KIRKLEES METROPOLITAN COUNCIL INVESTMENT & REGENERATION SERVICE

Reference No:	2024/62/93476/E
Site Address:	7, Hall Drive, Norristhorpe, Liversedge, WF15 7AH
Description:	Erection of single storey front extension and external alterations following removal of existing dormer extension.
Recommending Officer:	Nicole Helliwell

Officer Report

Drawing Number 21-143 - P - 02 - C

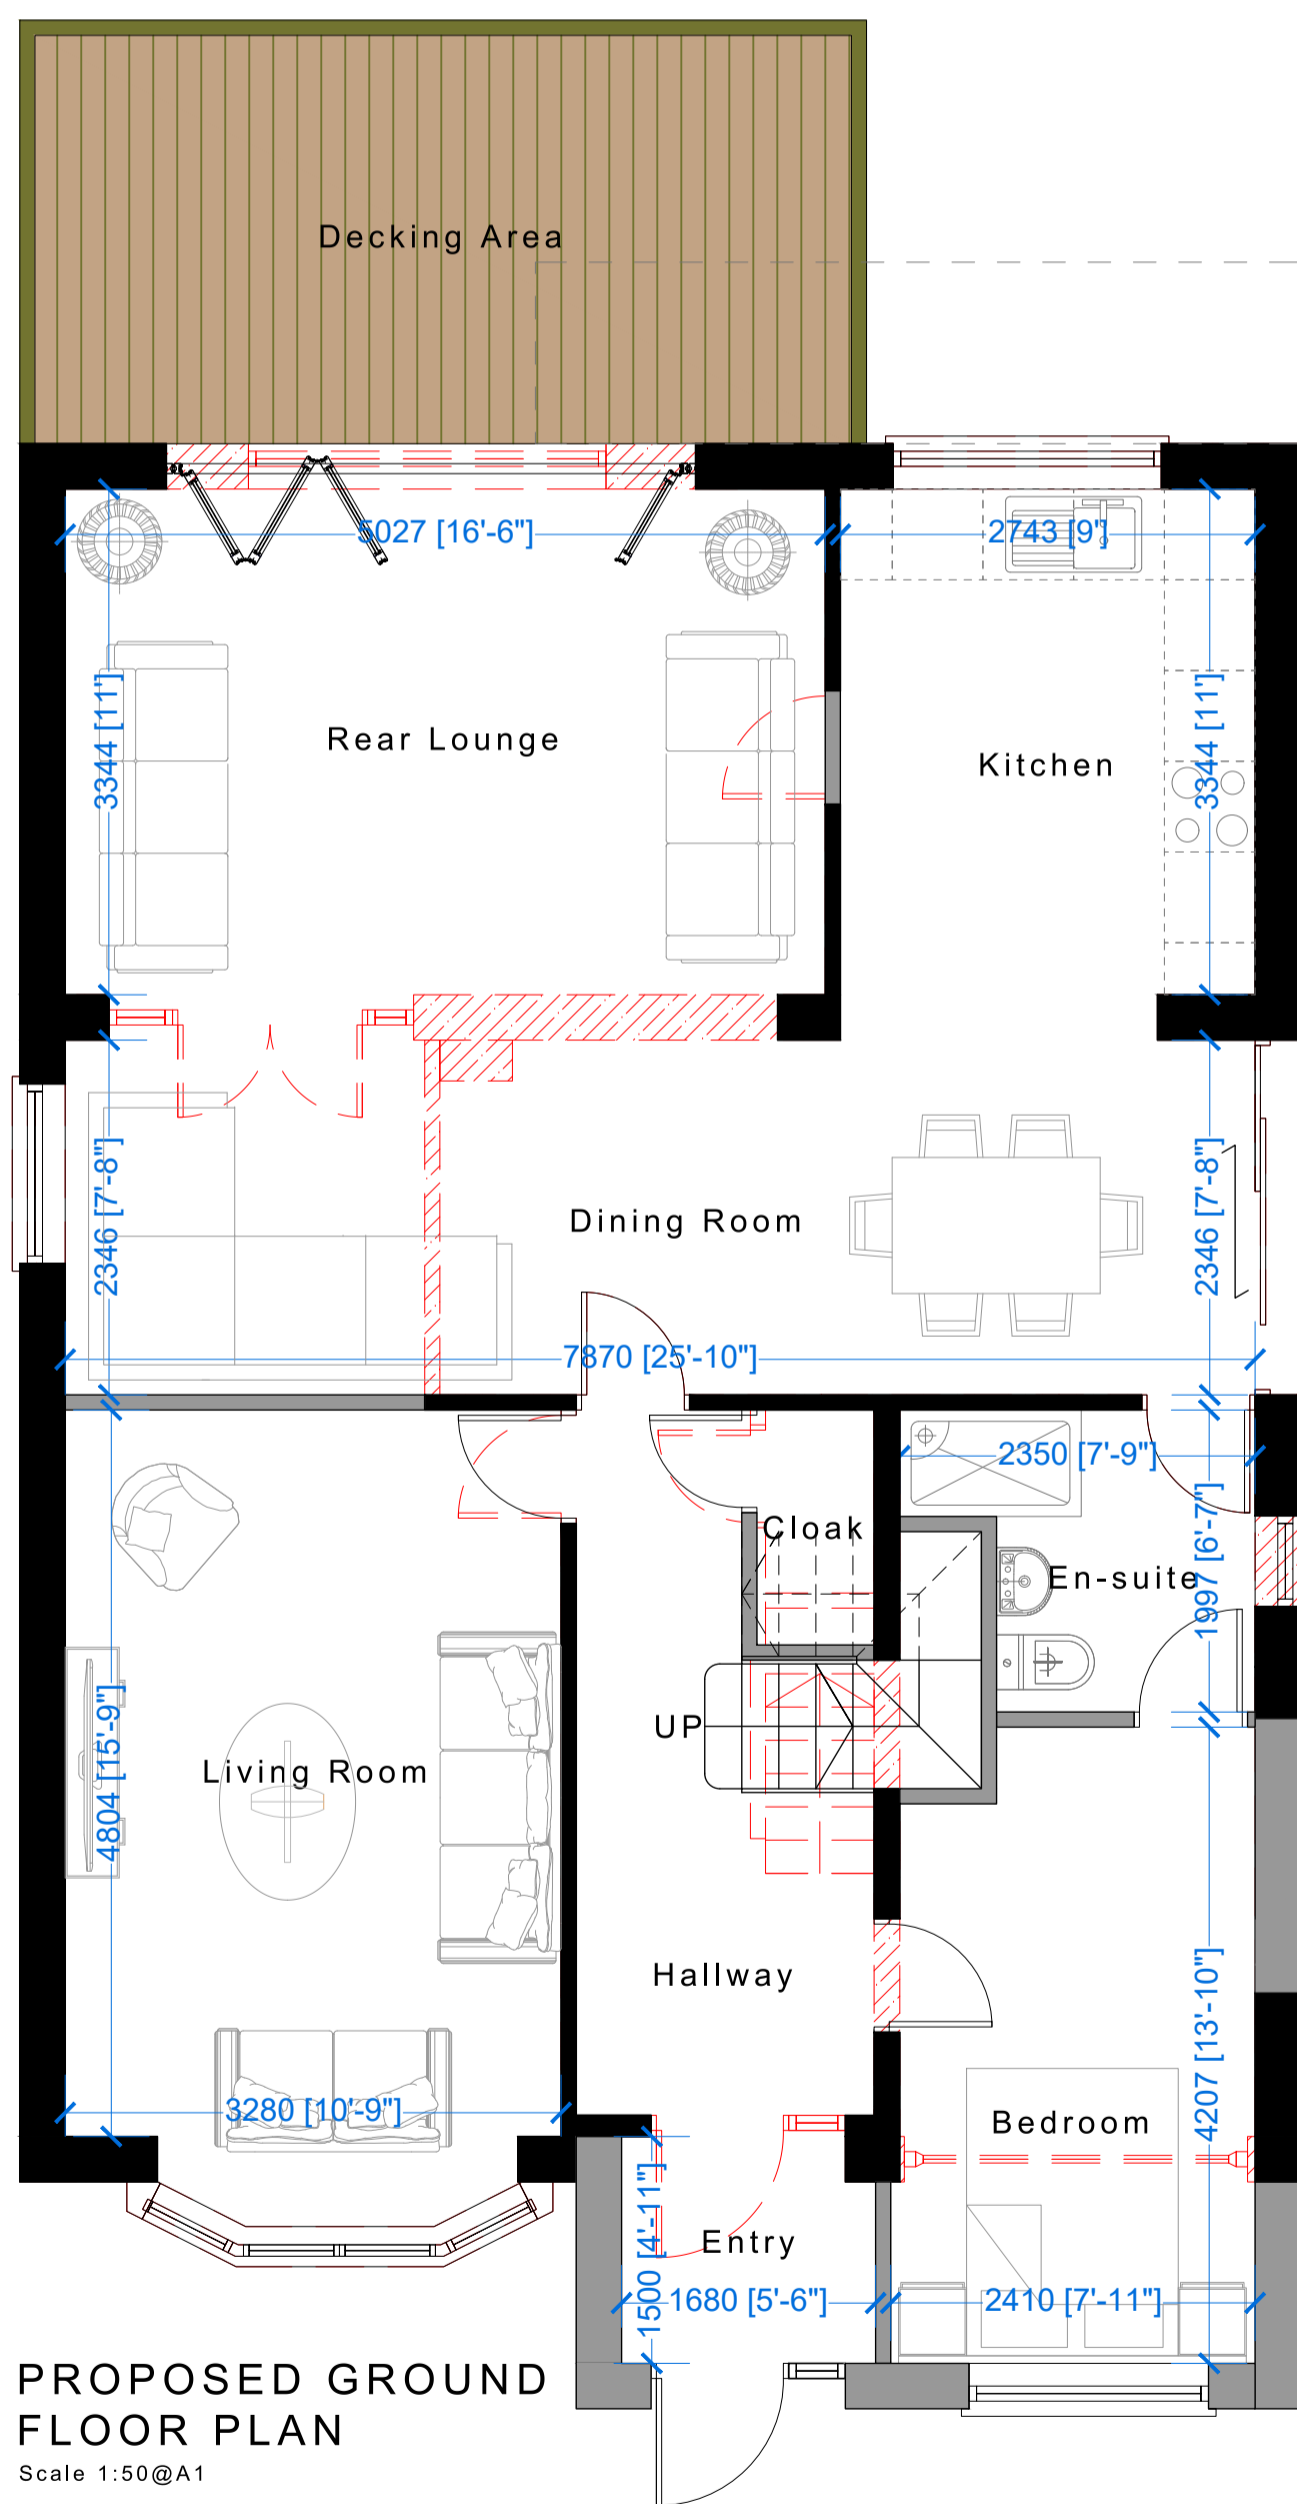
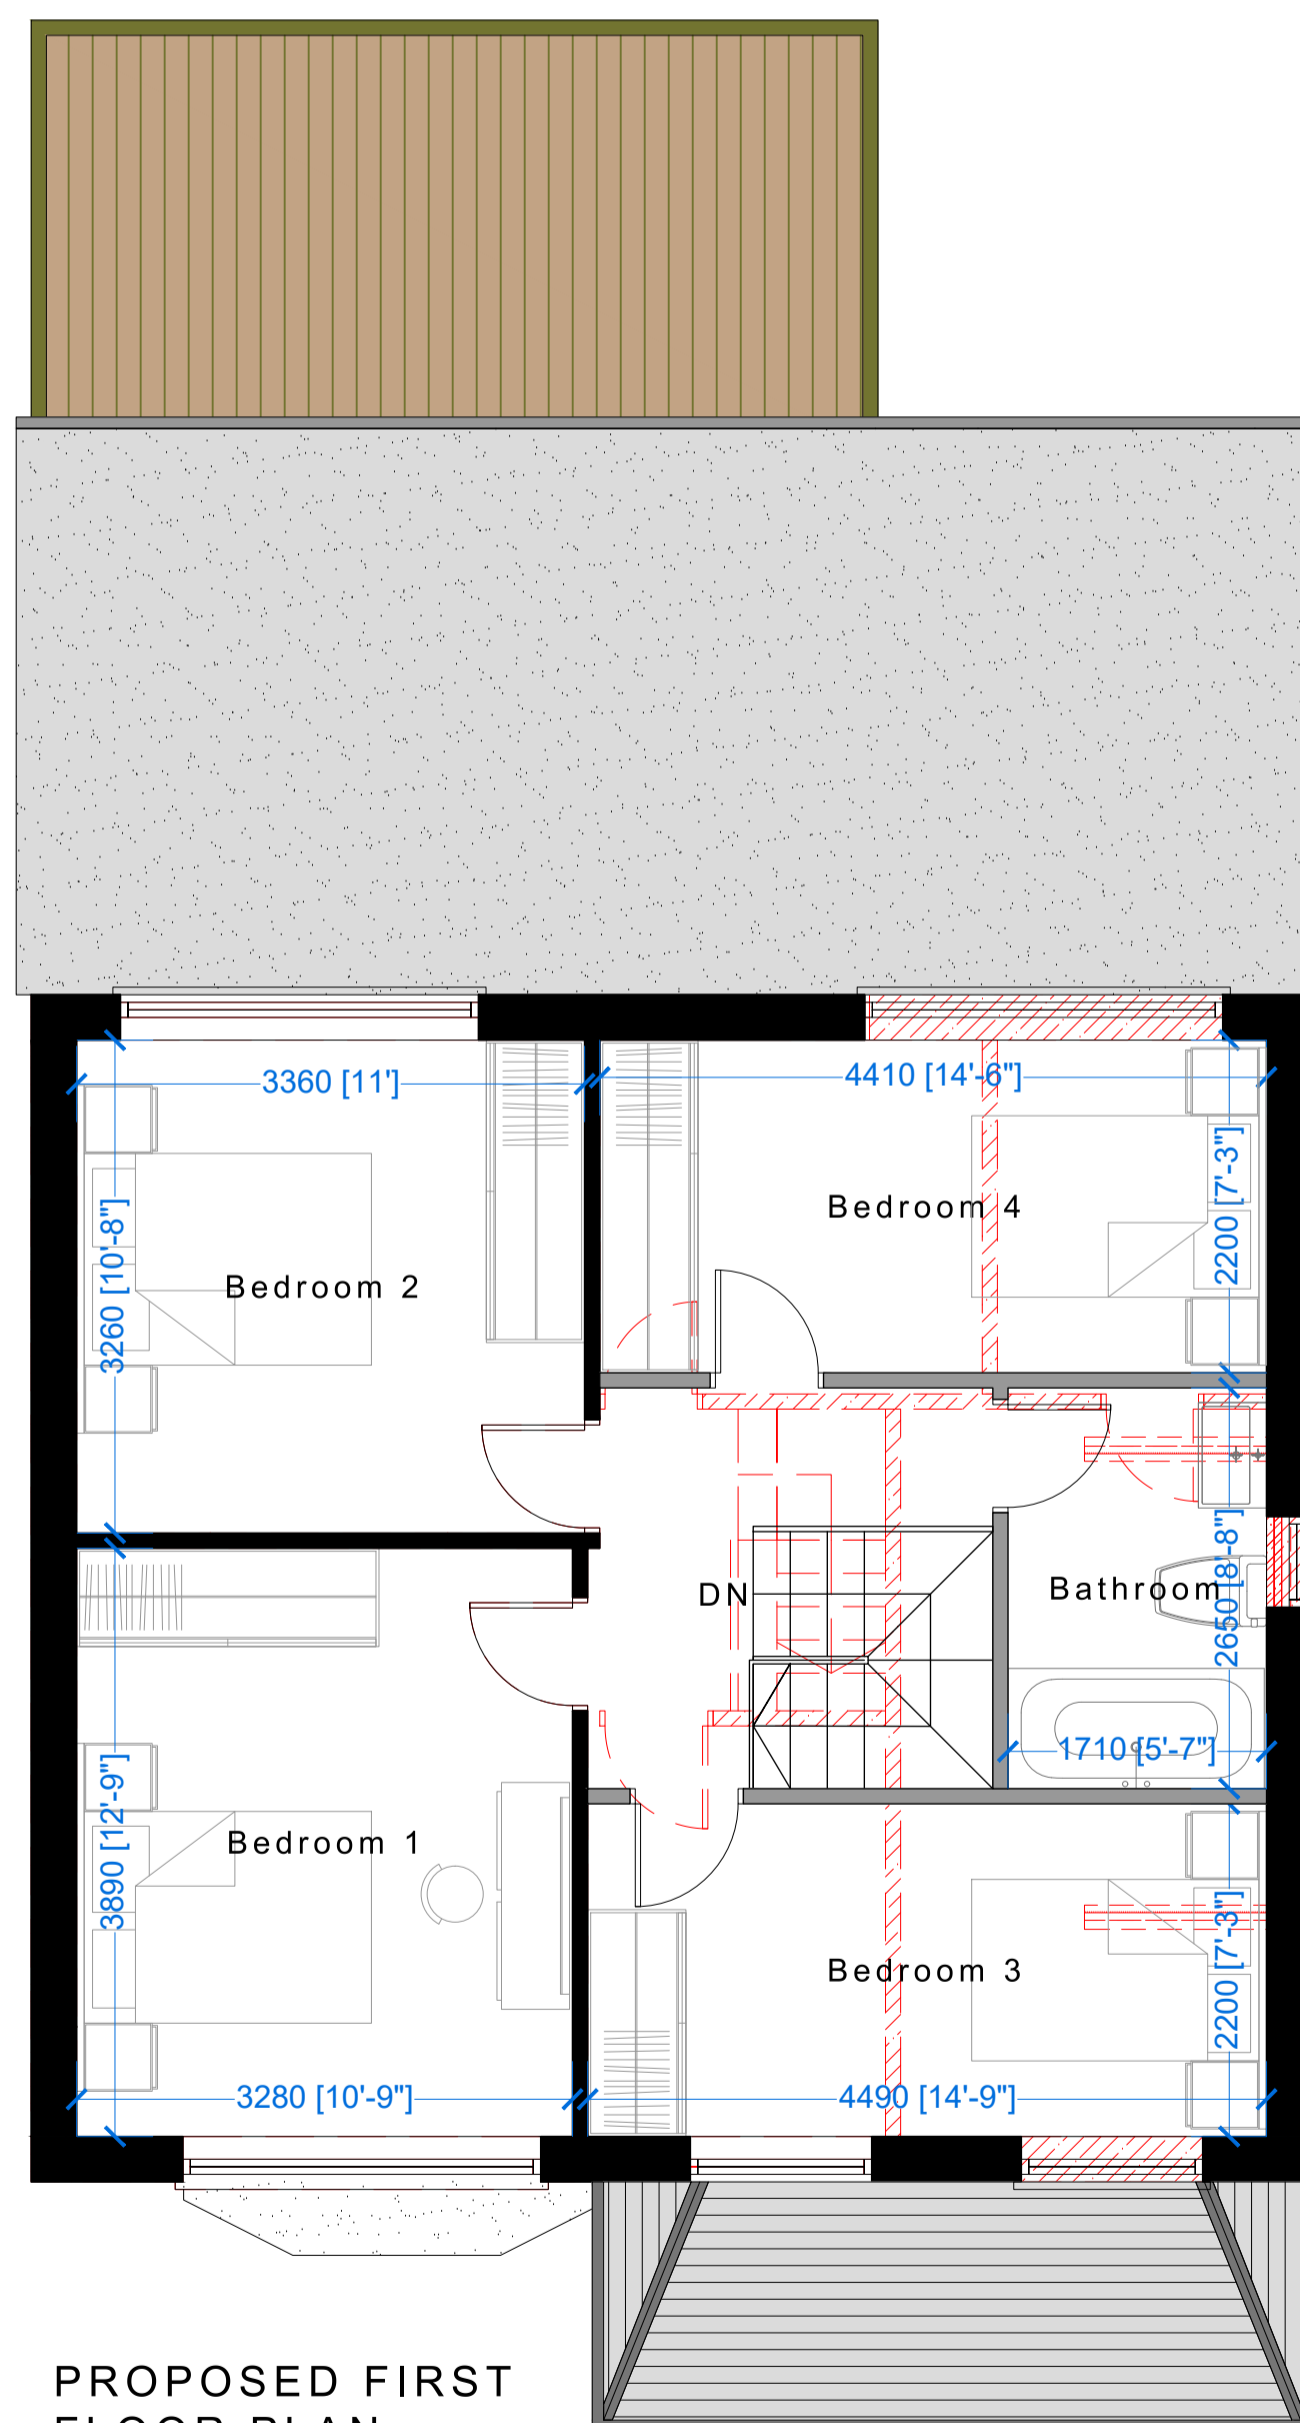
The proposed single storey extension would project approximately 1.5m from the front elevation of the original dwellinghouse. The enlargement would be constructed in a material palette to match the host property and would be appropriately designed. The extension would be modestly proportioned and would appear subservient to the host property. Furthermore, the enlargement would be sited on lower ground and would retain a distance of approximately 7.3m from the pavement such that it would not appear unduly prominent from public vantage points. For these reasons, it is considered that the proposal would not have any significant visual impact on the character and appearance of the host property and wider street scene.

The proposal would create an additional bedroom, which would intensify the domestic use at the dwelling. However, the submitted plans demonstrate that off street parking would be retained for three vehicles which is considered to represent a sufficient provision for a five bedroom dwellinghouse. Therefore, the proposed development is considered acceptable in accordance with Policies LP21 and LP22 of the Kirklees Local Plan, Chapter 9 of the NPPF, Principles 15 and 16 of the Kirklees House Extensions and Alterations SPD and the Highways Design Guide SPD.
